**Response to PINS Frodsham Solar
January 2026
FBF5AC63D**

Q4.4.2 NBBMA

Figure Title
Indicative Construction Compound and Access Track Layout

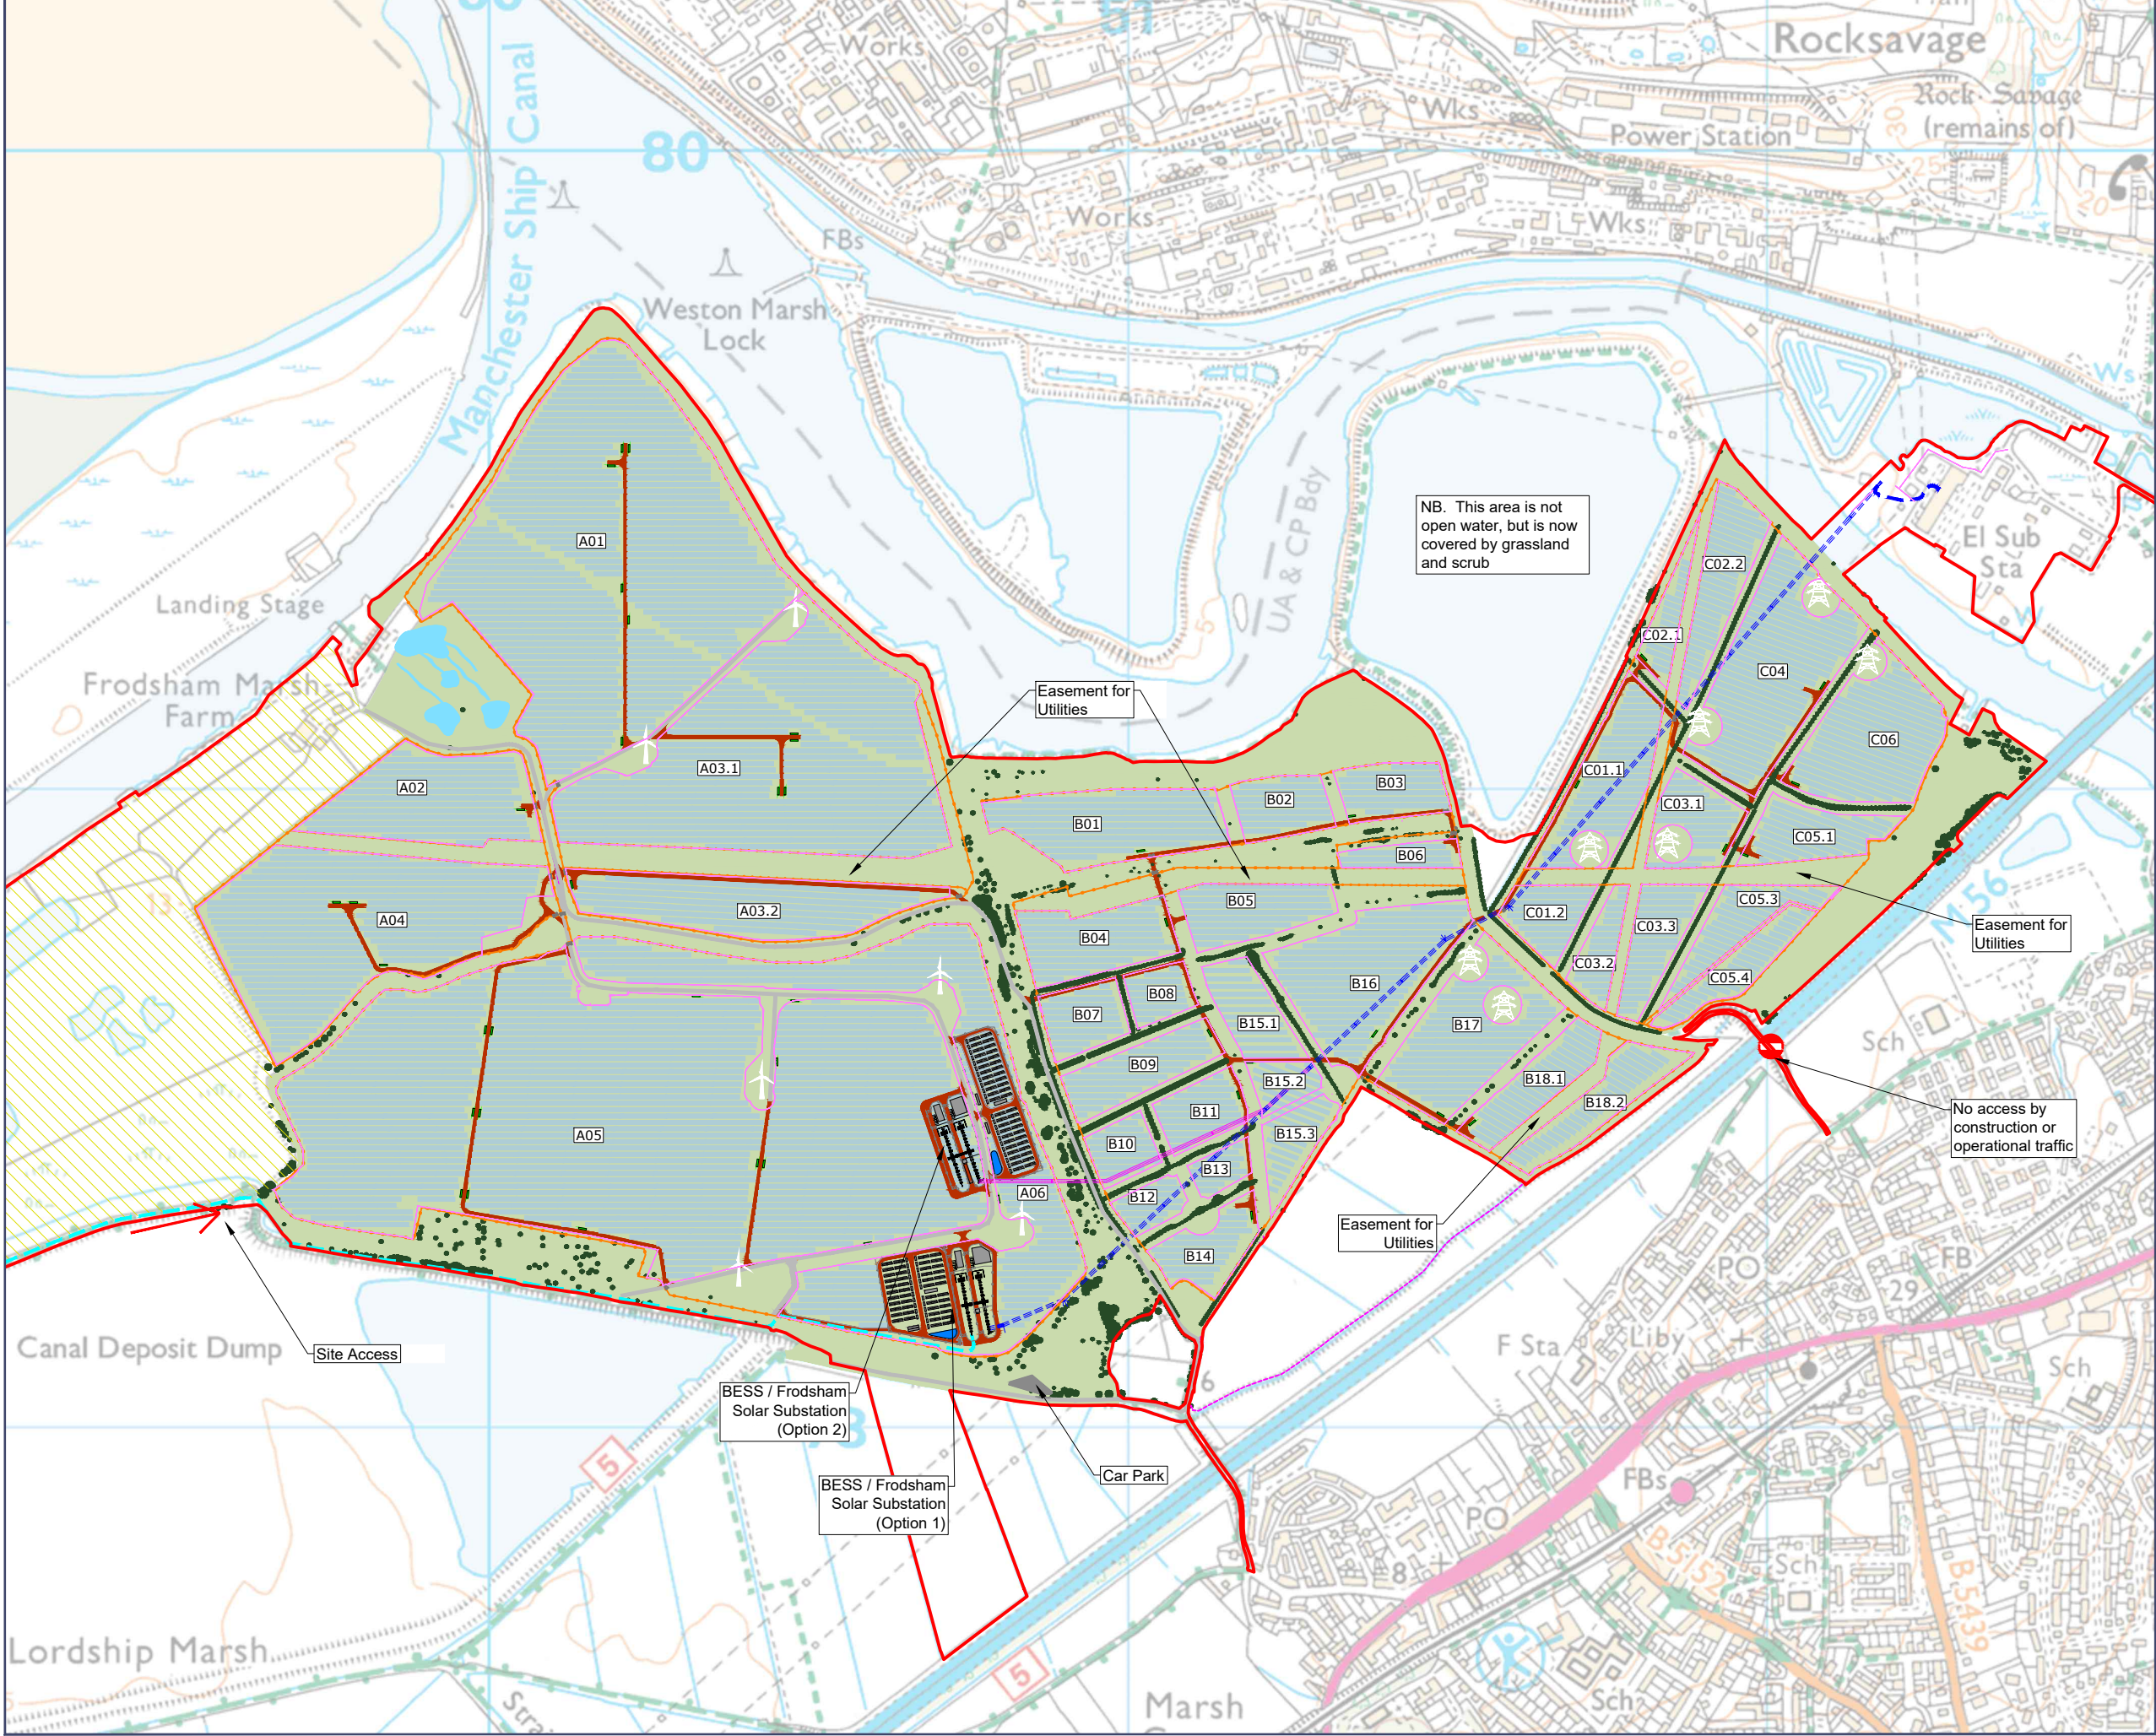
However, I am not satisfied with the response to CWACC7.51. The solar farm on the site of the Manchester Ship Canal Dredging Lagoons includes areas important to birds that move between the Mersey Estuary Special Protection Area and dredging lagoon cells or cells. The cells are numbered 1 to 5 and solar farm is proposed on cells 1, 2 and 5 with cell 3 proposed as a mitigation area.

The above data shows that the area is important for Lapwing, Golden Plover, Curlew and Ruff and the cell 2 is of particular importance. Therefore, I believe that putting solar panels on no 2 cell will have a significant impact on the birds using the area and that for lapwing, golden plover and Ruff this will have a significant impact on the birds using the Mersey Estuary Special Protection Area.

I am therefore proposing that the Non-Breeding Bird Mitigation area on cell 3 is extended to include all of cell 2. I do not think that extensive and expensive habitat creation works would be needed on cell 2, though that would be nice, as it is its current state that supports good flocks of golden plover and lapwing. The plan below shows the area of the grasslands that will be occupied by the solar farm. While much of this is only occasionally used by waders the area I have highlighted in red, cell 2, is particularly important. Even including for the improved habitat on no 3 cell I feel the reduction in total area will not be made up for in the improved habitat quality as these birds require extensive areas of open grassland. I am therefore asking for the no 2 cell, area outlined in red, to be taken out of the solar farm development and be used as part of the mitigation area.

The provision of cell 3 as a mitigation area is good. However as outlined in my answer to question 4.4.2 the area is not big enough and should be extended to include cell 2.

The whole area is important for the species mentioned earlier and the areas under the solar panels will become completely unsuitable for these species once the panels have been installed. Given the evidence presented in answer to question 4.4.2 I don't think the mitigation area will mitigate all the effects. This is because these species already use the area and there is a limit to how many more birds it can accommodate even with improved habitat quality. A better balance would be to increase the size of the mitigation area to include cell No. 2.
